Permit # 20116528

September 15, 2011

RE: Roof PV installations – Confirmation of available Roof Load Capacity
158 North Street, Portland, Maine

- Plan entitled “Module Layout”, drawing 10-0790-A1-10B as prepared by Applied Energy Technologies of Clinton Township, MI and dated 08/31/11.
- Applied Energy Technologies Cut Sheet for the Rayport Stainless Series Roof Ballast Rack assembly.

1:100 10-0790-A1-10B

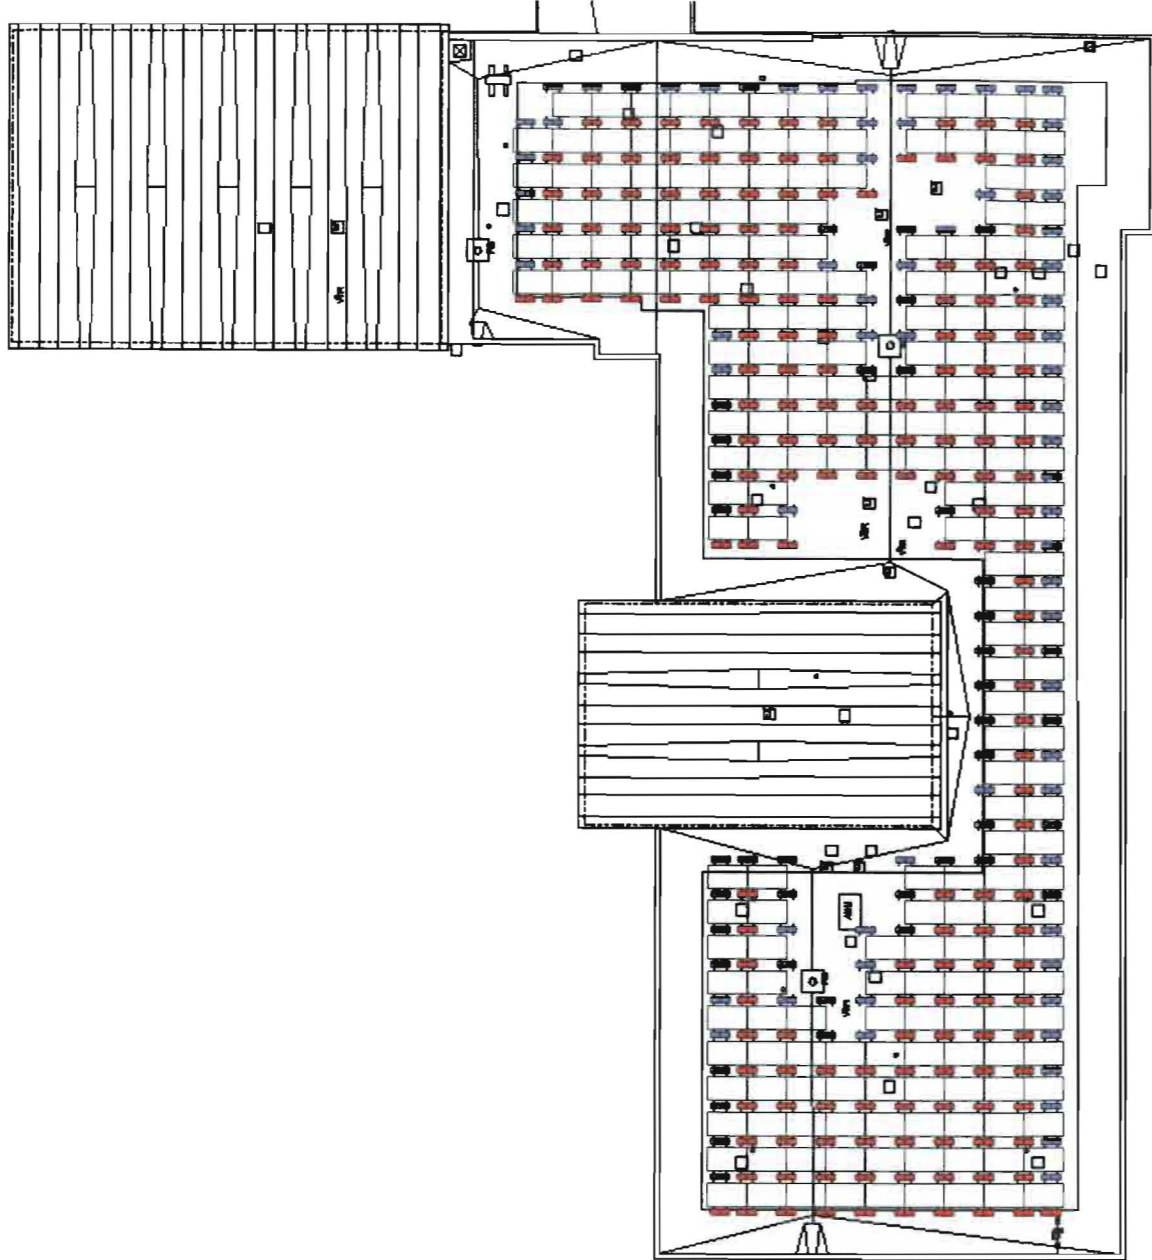
The intended PV array will increase the dead load on the roof surface by approximately 8.9 psf over the array field. It is our opinion, that the current plank spans, and provided intermediate support framing/foundation system recently introduced, has sufficient capacity to support the proposed array system.
